# KITTITAS COUNTY DEPARTMENT OF PUBLIC WORKS

TO: Jeff Watson  
FROM: Christina Wollman, Planner II *CW*  
DATE: June 8, 2009  
SUBJECT: Isotalo Short Plat SP-08-56

Our department has reviewed the short plat application and has the following comments:

ISOTALO SHORT PLAT

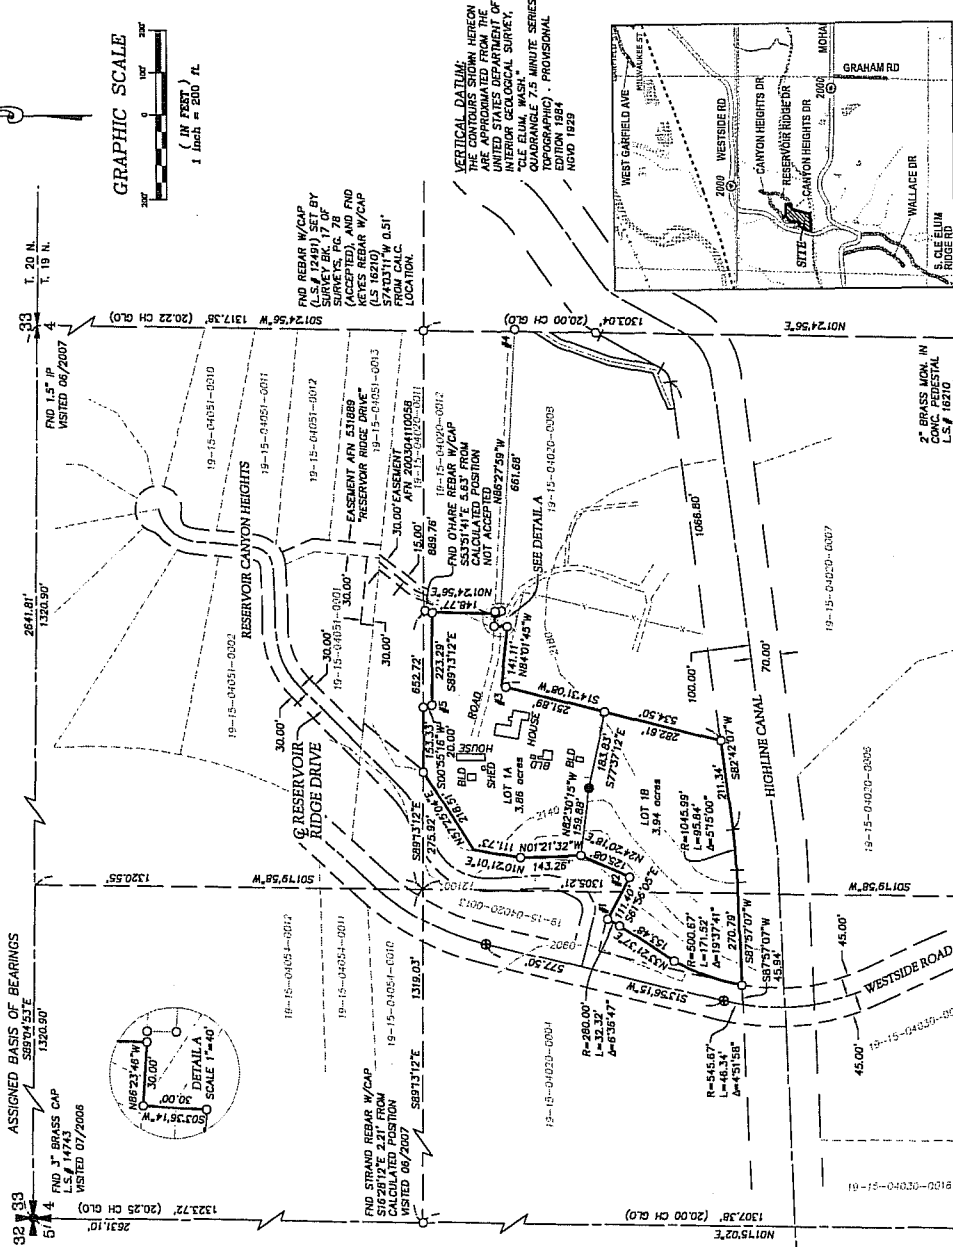
3. Geotechnical: Due to the steep slopes on the property, the applicant is responsible for conducting any necessary geotechnical reports to ensure future soil stability prior to beginning any construction activities.

4. Private Road Improvements: Access shall be constructed to meet or exceed the conditions of a High-Density Private Road that serves 15-40 tax parcels. Improvements are required from Westside Road to the entrance to Lot 1B. See current Kittitas County Road Standards, 9/6/05 edition.

- a. Access easements shall be a minimum of 60' wide. The roadway shall have a minimum width of 22', with 1' shoulders, for a total width of 24'.
  - b. Minimum centerline radius shall be 60'.

- c. Surface requirement BST/ACP.
  - d. Maximum grade is 12%.
  - e. Stopping site distance, reference AASHTO.
  - f. Entering site distance, reference AASHTO.

- j. All easements shall provide for AASHTO radius at the intersection with a county road.
  - k. A paved apron shall be constructed at the intersection of the proposed private intersection and the county road right-of-way.

5. Cul-de-Sac: A cul-de-sac turn-around having an outside right-of-way or easement diameter of at least 110 feet shall be constructed at the closed end of all dead-end roads serving 3 or more lots. The driving surface shall be at least 96 feet in diameter. Cul-de-sacs must also conform to the requirements specified by the 2006 International Fire Code. Contact the Fire Marshal regarding any additional cul-de-sac requirements.
